## Department of Transportation

January 2, 2024

SH 24G / Judge Orr / Stapleton  
El Paso County

RE: Esteban Rodriguez Subdivision Sketch Plan\_SKP237

# Directional Distribution

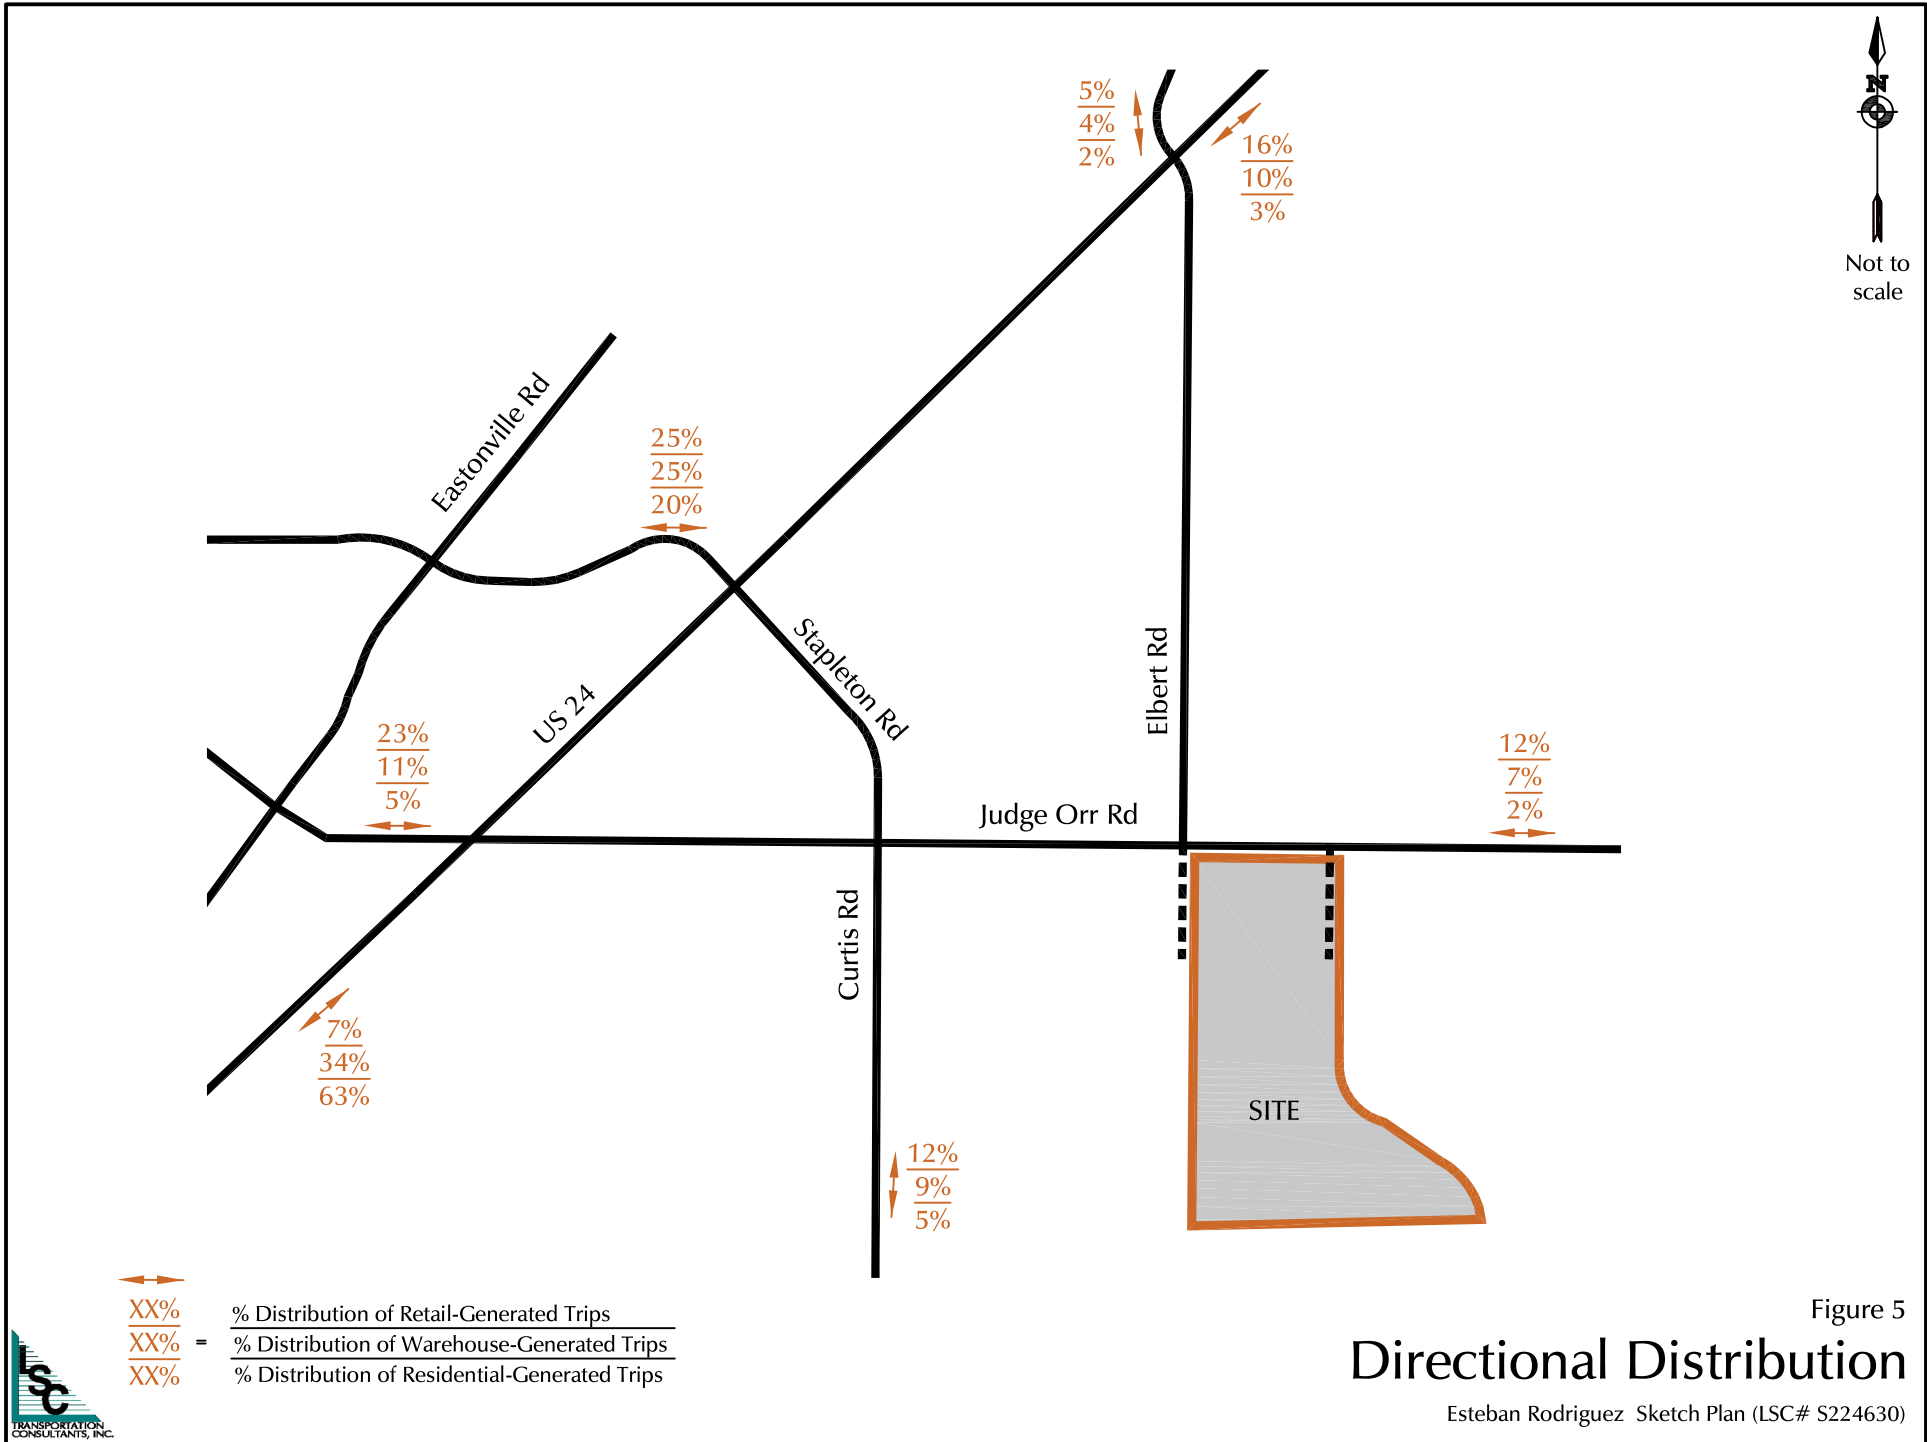
- Graphically show traffic distribution.
- Use the existing signal timings in the operational analysis. Signal coordination and optimization in all future scenarios is allowed. However, while optimizing- assume the following: 1) All left turns are protected, and 2) Right turn on red is not allowed. 3) Use the existing clearance times. In this way, we can account for possible safety improvements if needed later.
